**WELWYN HATFIELD BOROUGH COUNCIL
EXECUTIVE DIRECTOR - PLANNING, PUBLIC PROTECTION AND GOVERNANCE**

DELEGATED APPLICATION

Application No: 6/2021/3198/HOUSE
Location: 55 The Ridgeway Cuffley Potters Bar EN6 4BD
Proposal: Erection of a single storey rear extension, alterations to fenestrations and existing balcony above extension
Officer: Ms Kirsty Shirley

Recommendation: Granted

Drawing Number FEB2022_55TRW_03	Rev A
------------------------------------	----------

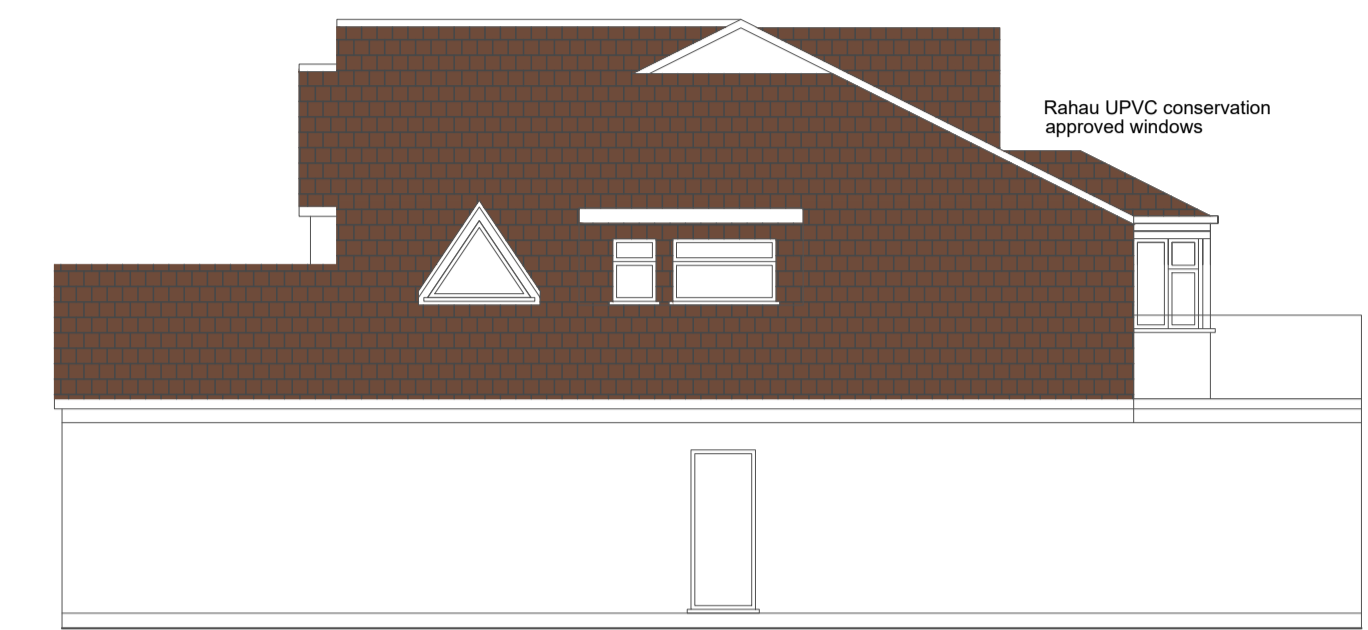
The positioning, size and scale of the proposed extension would ensure that the development would be subservient to the application dwelling and would not be readily visible from the street scene. The extension would feature a flat roof, and part of the roof of the extension would be used as a balcony, accessible from the first floor rear bedroom. The use of the roof as a balcony would not detract from the character of the dwelling and would be of such a size to not appear unduly dominant and discordant with the character and appearance of the application dwelling.

The proposal also includes alterations to the fenestration with the size, style and colour remaining the same as existing. The front door and rear bifolding doors would be finished in grey/black and it is considered that this colour palette would not fundamentally alter the character of the application dwelling or detract from the character of the area. However, the matching materials for the external decorations of the extension can be secured by condition to ensure that the development remains in keeping with the character of the dwelling.

2. The first floor glazing panel of the balcony facing towards 57 The Ridgeway must be obscure-glazed and shall be retained in that form thereafter.
